Planning Services Sign Permit Review Form

| Date of Submittal | Application Number | Applicant | Landowner |
|-------------------|--------------------|--------------------------------------|--|
| 2/28/2023 | SIGN2302-0001 | Blashfield Sign Company, Inc. | Wellco Contractors Inc. NCDOT |

| Contact Person | Jan Wright | Contact Number | 910-485-7200 |
|----------------|---|----------------|--|
| Sign Location | 2 Signs Proposed for 2 properties. One sign proposed lot 97 Rolling Springs Section 7, and one in NCDOT ROW Magnolia Drive & Nursery Rd. | PIN Number | 0506-34-8997.000 0526-50-6140.000 |

**PROJECT NAME**  
**SUBDIVISION SURVEY**  
**ROLLING SPRINGS**  
**PB 23, PG 14 &**  
**RIGHT-OF-WAY**  
**ABANDONMENT**

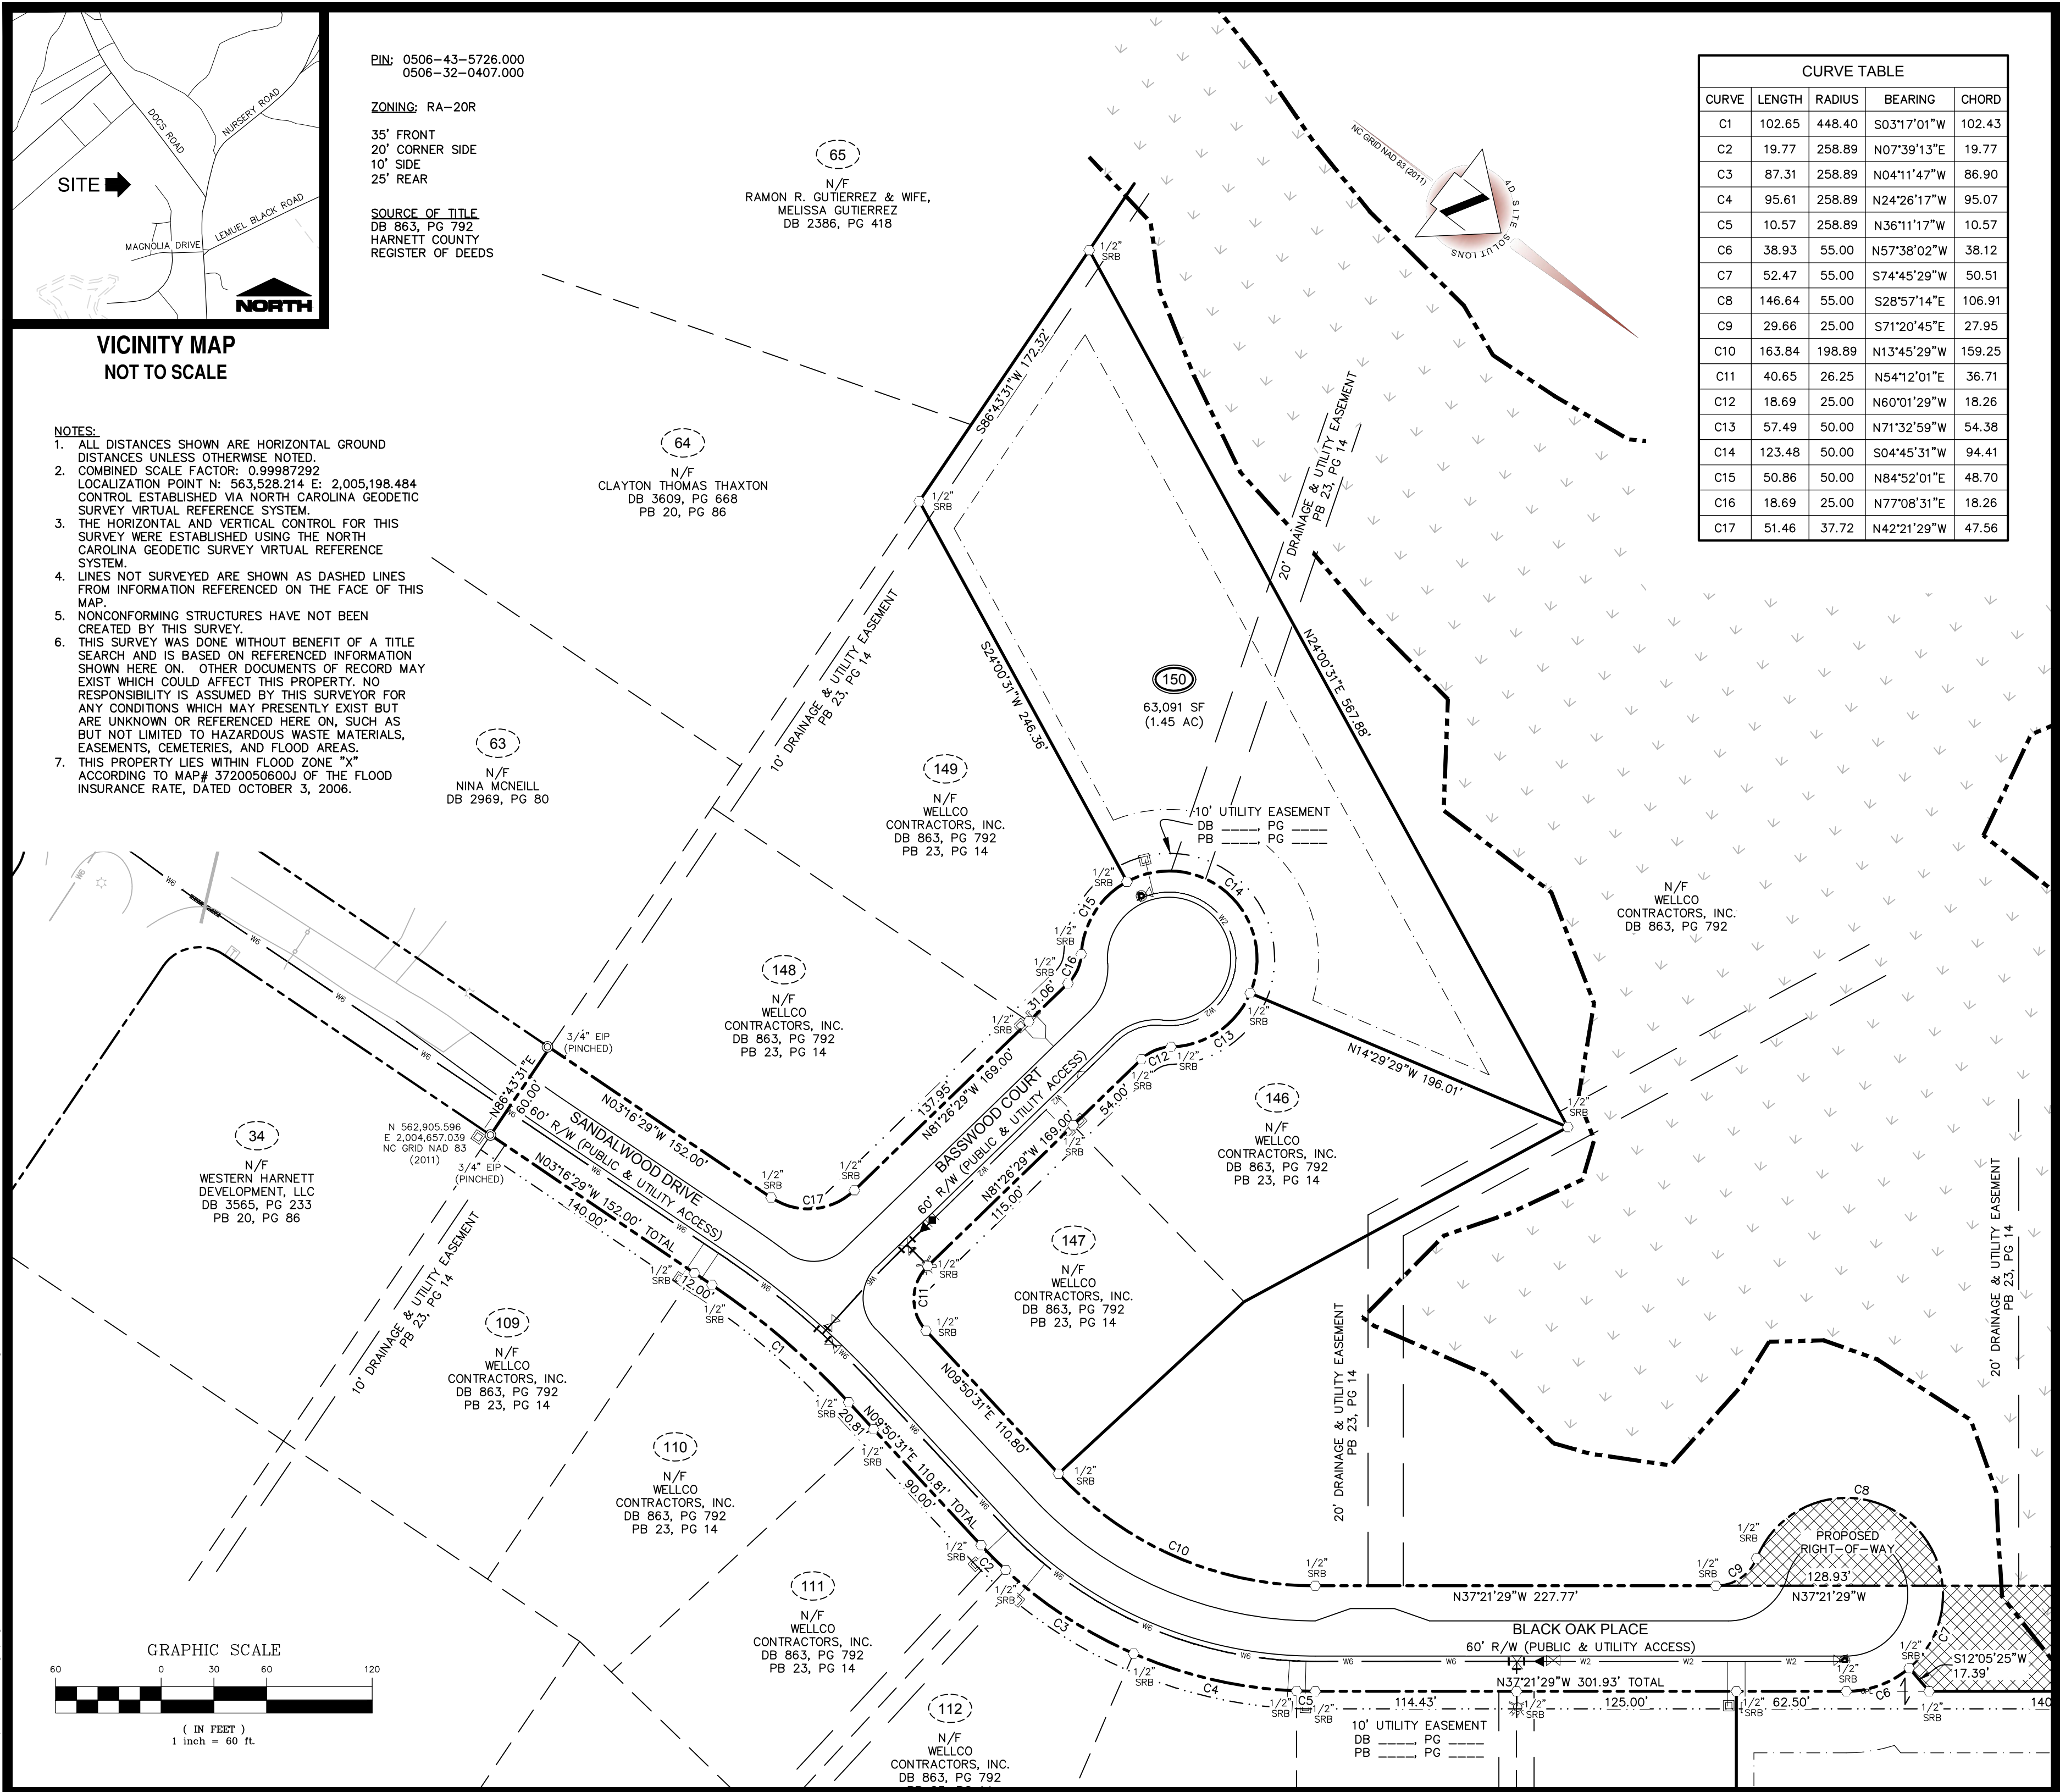
| Comments | <p>1. Harnett County does not have the authority to permit a sign in the NCDOT ROW. An encroachment agreement may be required from NCDOT to construct a sign in the ROW. Documentation from NCDOT of approval to place sign in the ROW must be produced. The sign in the ROW and the sign proposed on lot 97 will require 2 permits. Please contact Jeananne Dawson with Harnett County Central Permitting at (910) 814-6421 or jdawson@harnett.org.</p> <p>The sign will be required to meet the dimensional standards of the subdivision sign section in the Unified Development Ordinance and any applicable requirements from Central Permitting and the NC Building Code.</p> |

2. No setback information provided on the site plans. Please provide the distance from the sign to the property lines and the ROW. 10' is required from the ROW to the sign, or 20' from each ROW if placed at an intersection.

3. Only one PIN# was provided for 2 properties. For the sign to be constructed on lot 97 Rolling Springs Section 7, the PIN# is 0506-34-8997.000. This information should be updated on the land use application.
